9 September 2015

File No: R/2015/8/A & R/2015/9/A
Our Ref: 2015/440140

RE: Barangaroo South, SSD 6957 – Crown Hotel and Resort & SSD 6956 – Remediation and Earthworks Stage 1B

Figure 2: Applicant supplied image of the Foreshore Promenade

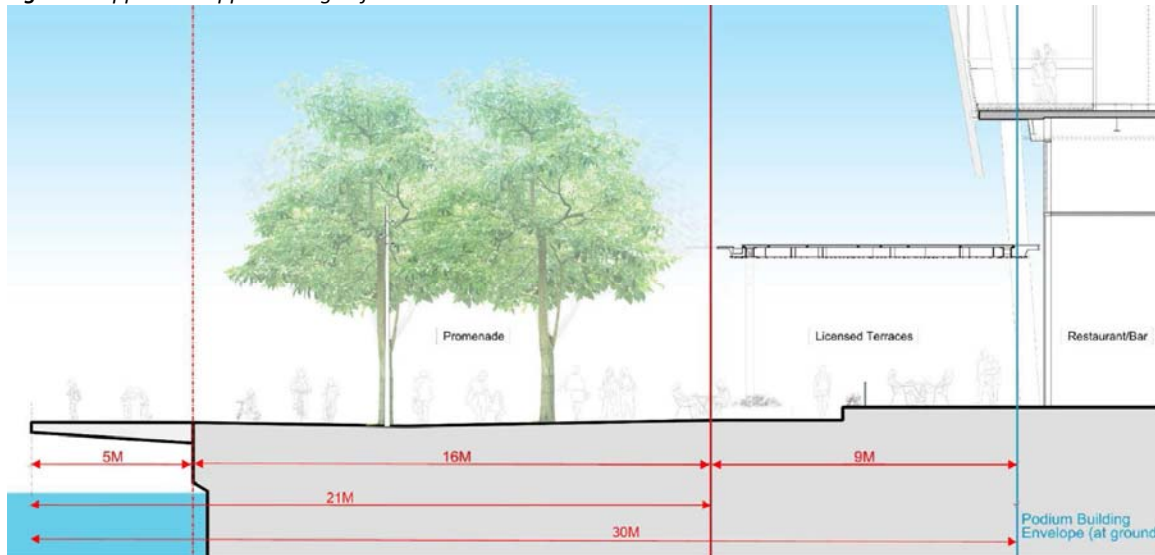
The disruption of the existing Concept Plan and zoning restrictions preserving a continuous waterfront promenade is not supported. A 30m wide setback applies from the northern cove (now Nawi Cove) in Barangaroo Central. The Barangaroo Central promenade has, from the edge of the caisson sea wall – a timber boardwalk, an informal walking trail containing a central row of trees, a second row of trees, a paved walking and cycling path and a third row of trees at the grassed edge. This division of pathways gives users options for promenading, commuting, exercising and socialising. The continuous parkland waterfront is a strong element of the existing Concept Plan that varying the approved outcome runs counter to the requirements of the Barangaroo design competition jury and is not supported by the City.

The Crown SSD DA and MOD 8 have a waterfront setback between 15-20m. The restaurant and bar outdoor dining terraces privatise and inhibit the continuity of the 30m setback.

Arising from the above, the loss of a continuous row of waterfront tree planting – from three rows of trees down to two rows – and the way in which pedestrians and cyclists will have a tighter fixed path are considered a poor, and avoidable, outcome.

The Barangaroo Central promenade should continue along the Crown frontage to unify the public domain. Greater clearance should be provided between the sea wall and any Crown related structures. A third row of trees should be preserved.

- Maintain the continuity of the existing 30m wide waterfront promenade;
- Develop concepts or design principles for the waterfront promenade's structures
- Wind assessments for Concept Plan MOD 8 and the SSD DA should adopt the same methodology for assessing the severity of the impact on pedestrian comfort and safety;
- Shopfront and Signage Strategies should be prepared to guide the detailed design;
- Provide weather protection at all building entries; and
- Limit uses under public roads to common areas and accesses.

Figure 4: Elevation depiction of proposed signage

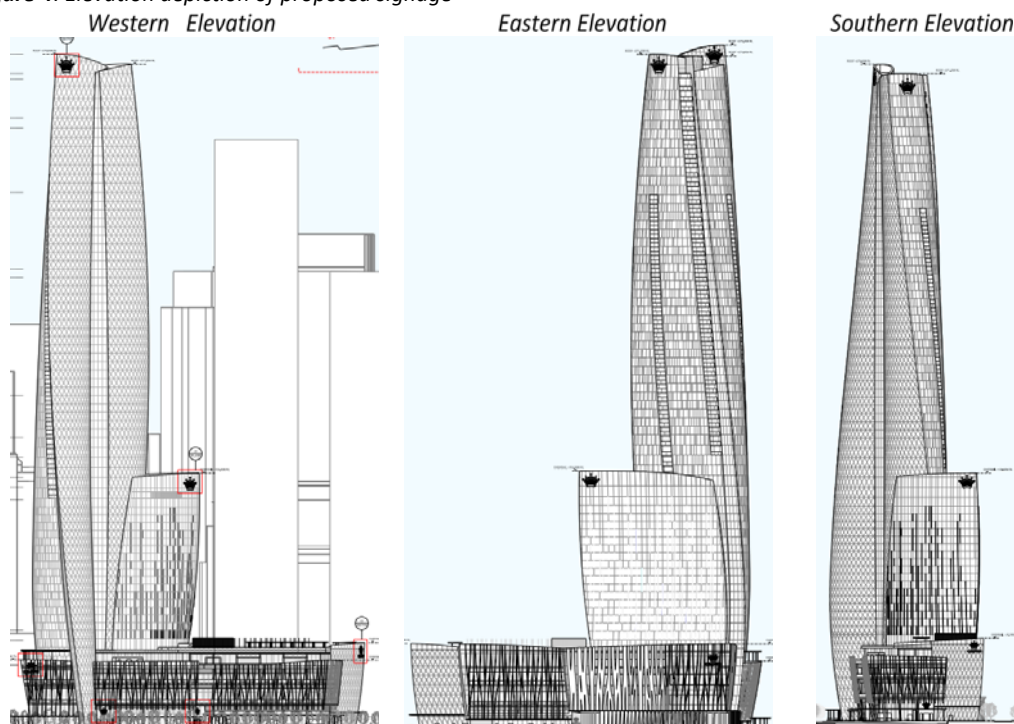
Signage visible from the public domain, both night and day but particularly when illuminated at night, should be integrated to the quality and form of the building and not detract from the vista of the public waterfront.

It would be excessive to have building identification signage over every pedestrian entry to the building, e.g. the entry doors for the through-building links, when the casual observer will have already been exposed to podium and major entry signage.

Shopfront and Signage Strategies should be prepared to guide the detailed design phase toward integrated approaches that contribute positively to the public domain.

Figure 5: Wind Mitigation Measures including trees, glass blades, canopies and deployable shades

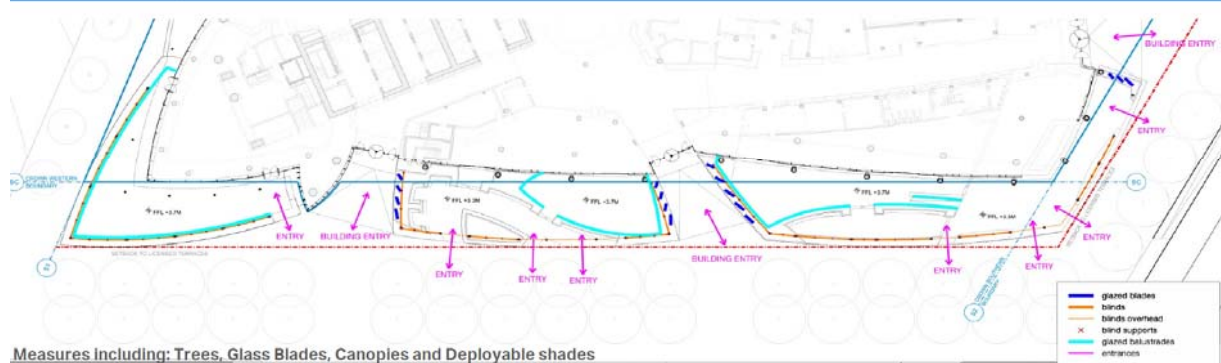
Localised wind amelioration measures are nominated for the privatised waterfront terraces within the development boundaries, including glass blades and horizontal blinds along the outdoor dining zones. These devices will close off the terraces to the promenade and result in poor interaction between the public and private domains.

Wind shields/skirts should be incorporated into the built form of the tower and podium to address downdrafts on both the privatised and public areas of the base.
